From: Adrian Hoy [REDACTED]
Sent: 21 January 2019 14:52
To: Simon Davis <Simon.Davis@arun.gov.uk>
Subject: Re: BR/214/18/PL

From: Simon Davis <Simon.Davis@arun.gov.uk>
Date: Monday, 21 January 2019 at 12:43
To: Adrian Hoy [REDACTED]
Subject: RE: BR/214/18/PL

Drg No: **RNHB.PLAN 2**

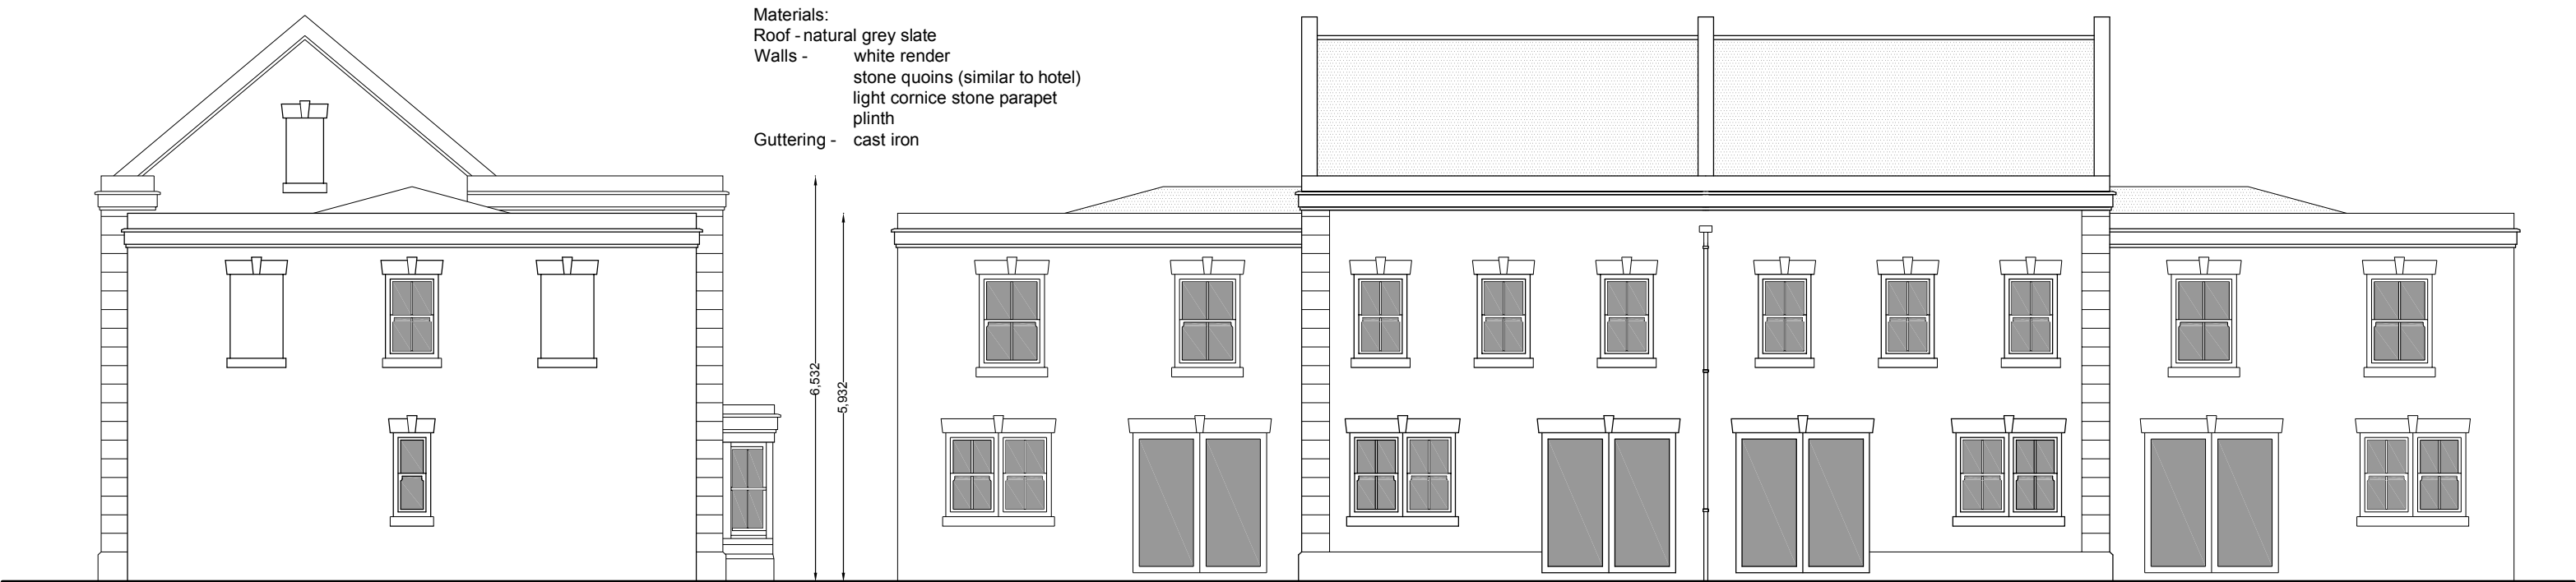
We would welcome the omission of the roof terraces but the objection would still remain to the current proposal and as such, would need to be refused.

- reduction in the number of dwellings from 4 to 3 with resulting smaller built form
- say if the southernmost dwelling were removed then this part of the site could become curtilage to the new southernmost dwelling – this would mean that this part of the site remained open allowing views through to the hotel
- two storey terraced built form with pitched roofs
